From: Amanda Scholes on behalf of Planning.Responses
Sent: 17 February 2021 09:48
To: Planning Scanning
Subject: FW: Planning Consultation on: Y/148/20/DOC

Condition 12- surface water drainage design

Application No: Y/148/20/DOC
Registered: 23rd December 2020
Site Address: Bonhams Field Main Road Yapton BN18 0DX
Description of Works: Approval of details reserved by condition imposed under ref Y/1/17/OUT relating to Condition Nos 12 - surface water drainage scheme, 14 - maintenance & management of SuDs and 16 - drainage strategy.

PERMEABLE CONCRETE BLOCK PAVING
DRIVE CONSTRUCTION DETAIL
Scale 1:20

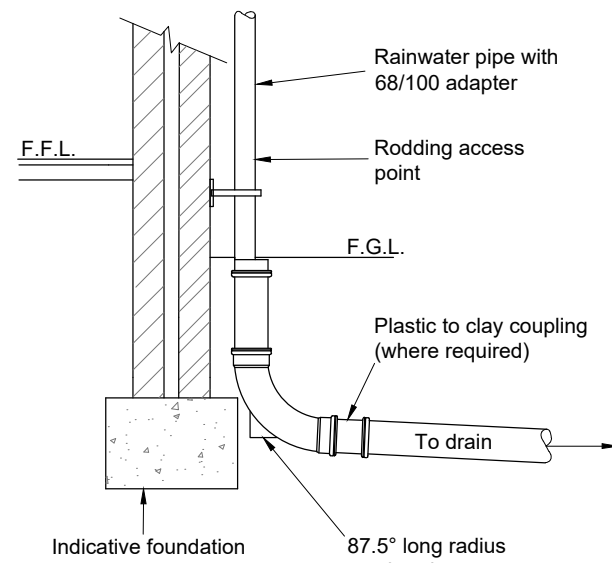
8. Is terram to be provided to separate the sub-base from the clean stone on the permeable paving?

Yes, this has been provided on the latest revision of Drawing 1501B Construction Details which is attached. Okay. *The baffle is stated to always be 450mm deep, yet you have two catchments where water level will exceed this. Should the baffle height be adjusted in these two catchments?* We have updated the construction detail and included a note that the baffle height will vary based on the minimum depth of the subbase shown on the General Arrangement drawing. Okay.

CLIENT Seaward Properties Limited	
PROJECT Bonhams Field, Main Road, Yapton	
TITLE Site Layout Proposed Drainage Plan Sheet 1 of 4	
DRAWN M Pacifico	DATE June 2020
ENGINEER S Magowan	CHECKED SRM
PROJECT NO. 23018	
SCALE 1:200 @ A1 / 1:400 @ A3	
1221 A

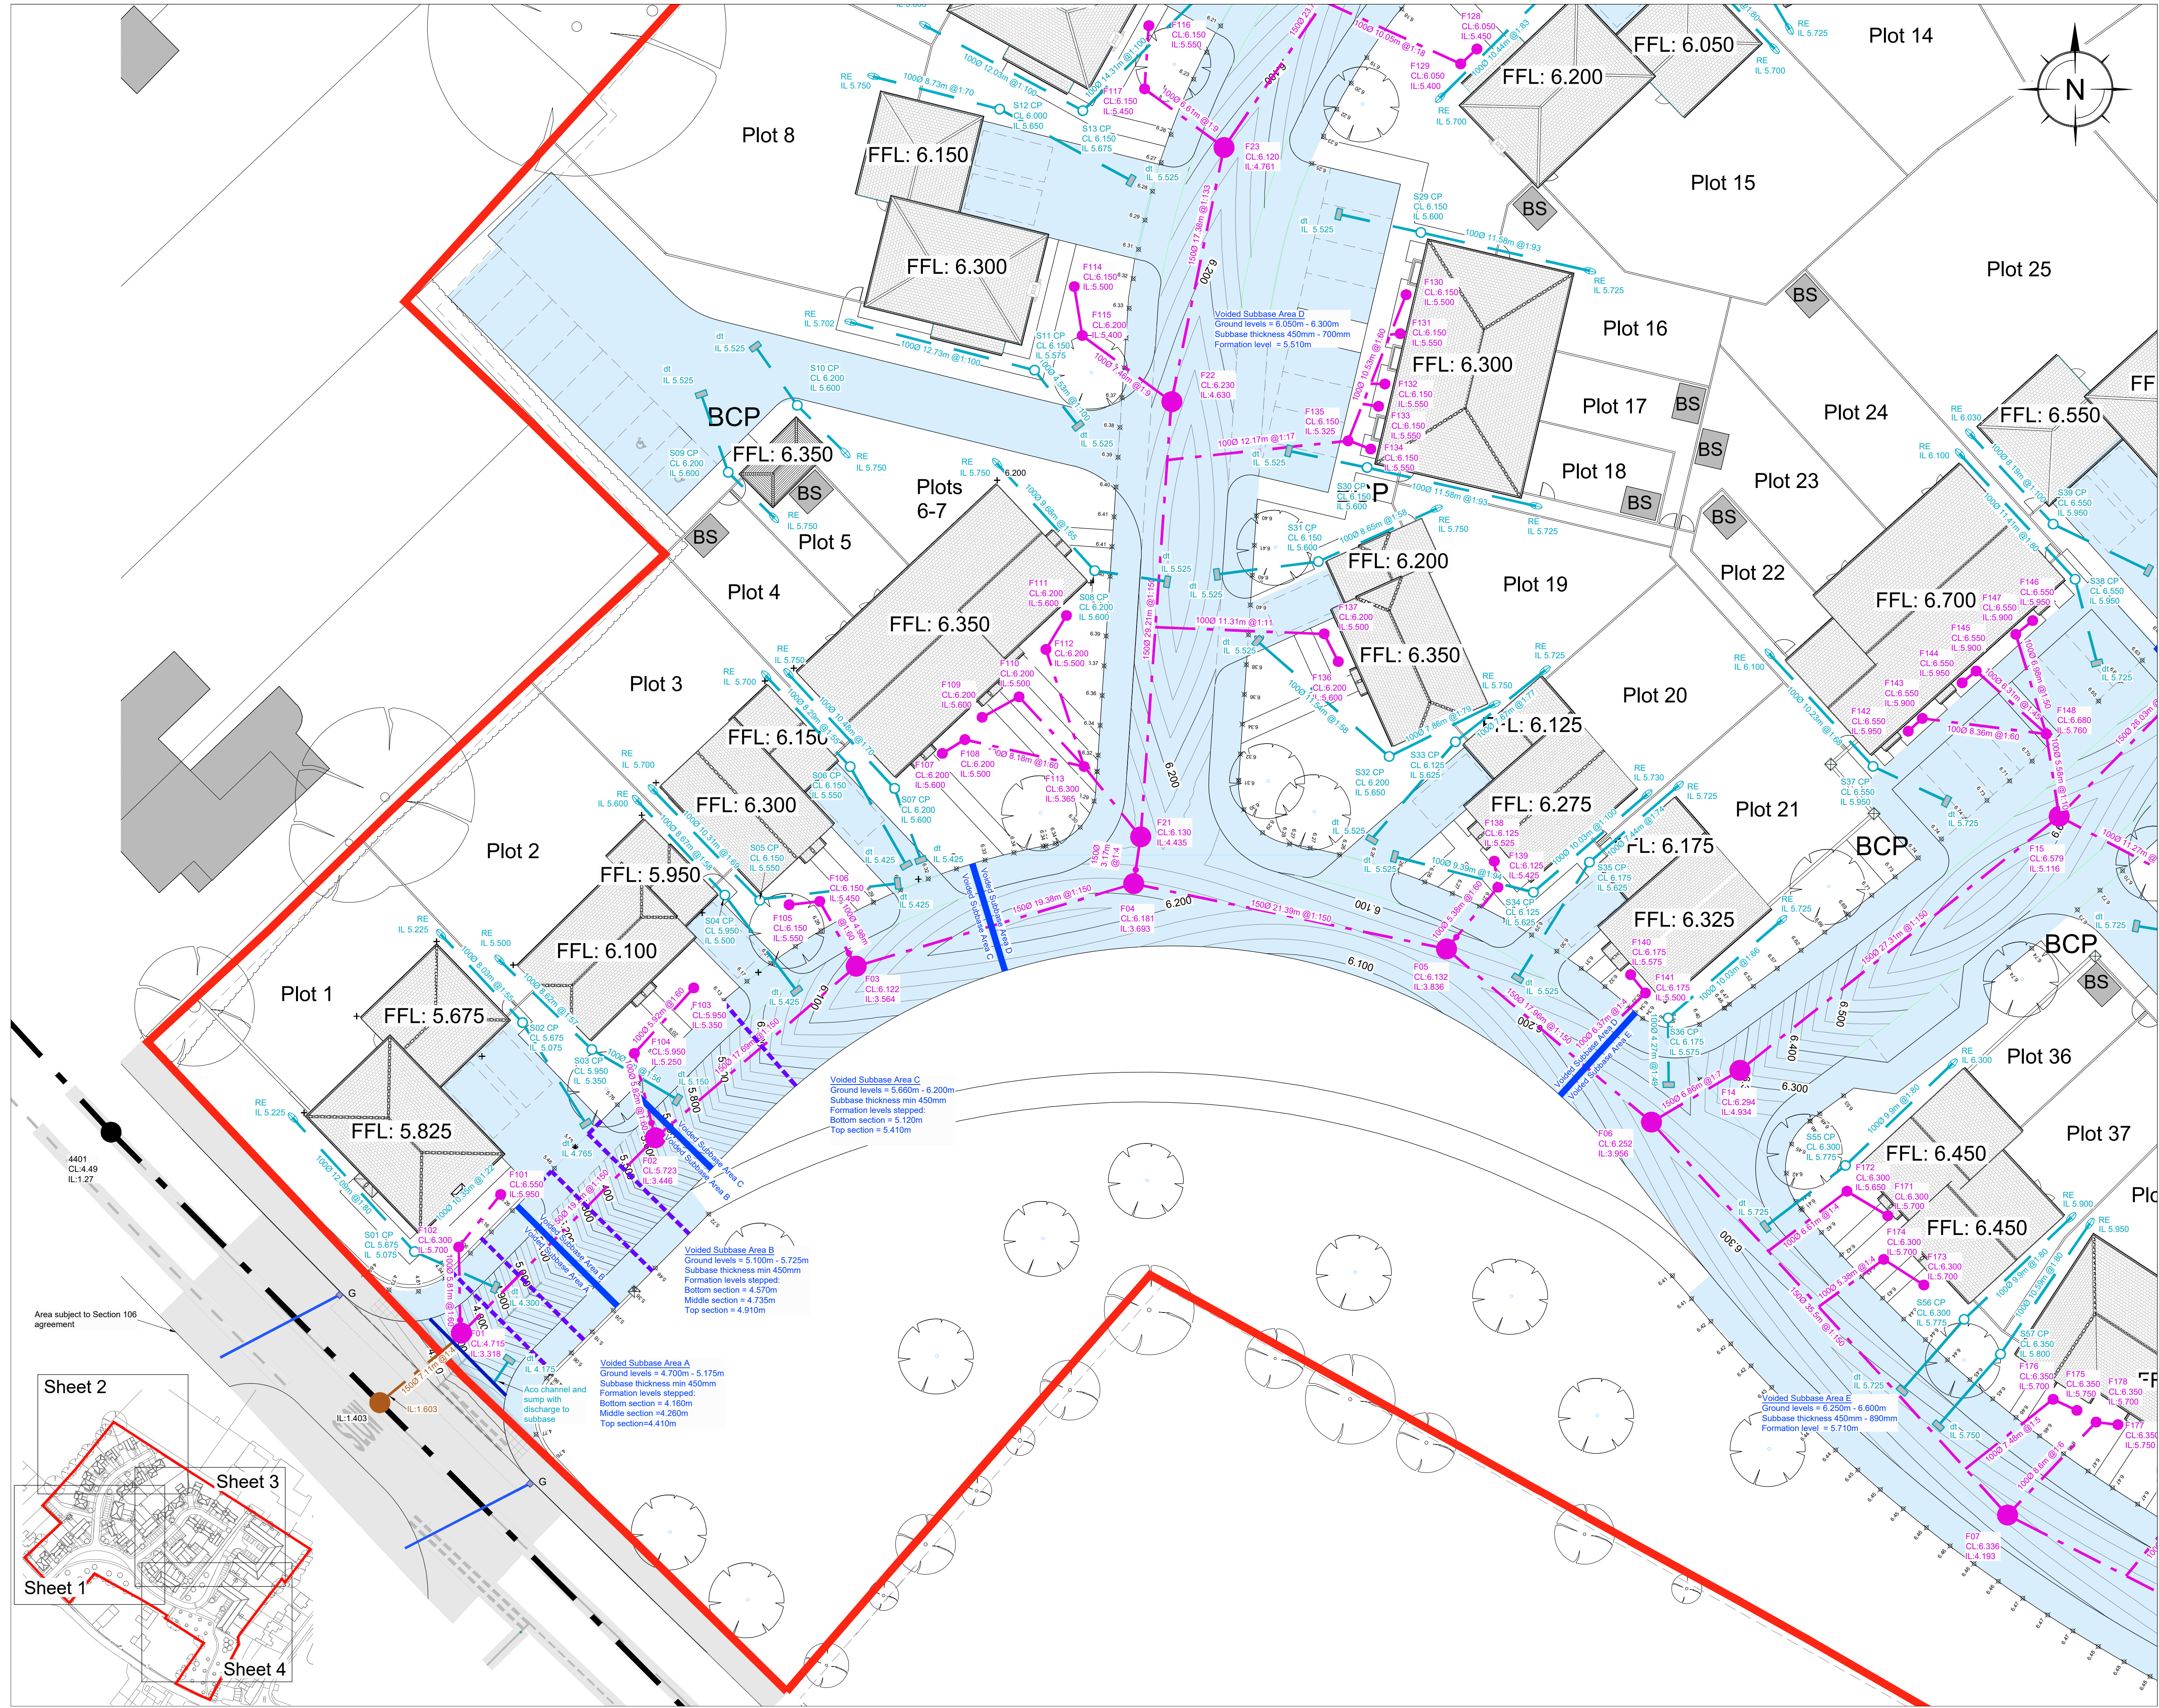
5. I note that in areas G and H you are proposing to locally deepen the sub-base around diffusers. Inlets should be set above the 1 in 10 year plus 40% cc event water level, they certainly should not be set below the base. Please reconsider the design here and check all areas have inlets set above the 1 in 10 year plus 40% climate change water level.

Further to the revisions above we have removed the locally thickening with the diffuser tanks have now been placed just above the formation level in these catchments, which is the highest point the diffuser tank can be set to ensure that minimum pipe falls and cover can be achieved. There are many areas where incoming connections are set below the 1 in 10 year, let alone 1 in 10 year plus 40% water level. This is not acceptable, please review. There is even one diffuser tank proposed below formation level. I note your comments about minimum falls, however your current proposals do not meet requirements. You may need to take some of the downpipes to more local features in some locations.

All diffusers are now either at or above formation level as discussed. This has been accepted elsewhere by Arun District Council including on Planning Application A/79/20/DOC approved in July 2020. Policy requirement for major applications is to have all incoming connections set above the 1 in 10 year plus climate change event water level. The policy requirement comes from both the suds manual and BRE365. The suds manual references that incoming flow to infiltrating structures should be free and unimpeded. BRE365 makes you calculate the storage volume required between the base of the soakaway and the incoming invert for the 10 year event (based on the fact this is the design event in this section of the guidance), specifically "Storage must equal or be greater than inflow minus outflow, defined above, and is the required effective volume available between the base of the soakaway and the invert of the drain discharging to the soakaway.". We acknowledge that on sites it will not always be possible to have the invert level above the 1 in 100 year plus climate change event storage, but do require flow to be free and unimpeded for more frequent events. Please demonstrate that your design meets policy requirements.

I note that pipe falls of 150 diameter pipes are at 1:167, this is below the gradient required to achieve 1m/s self-cleansing velocity. Please ensure all pipes achieve minimum falls.
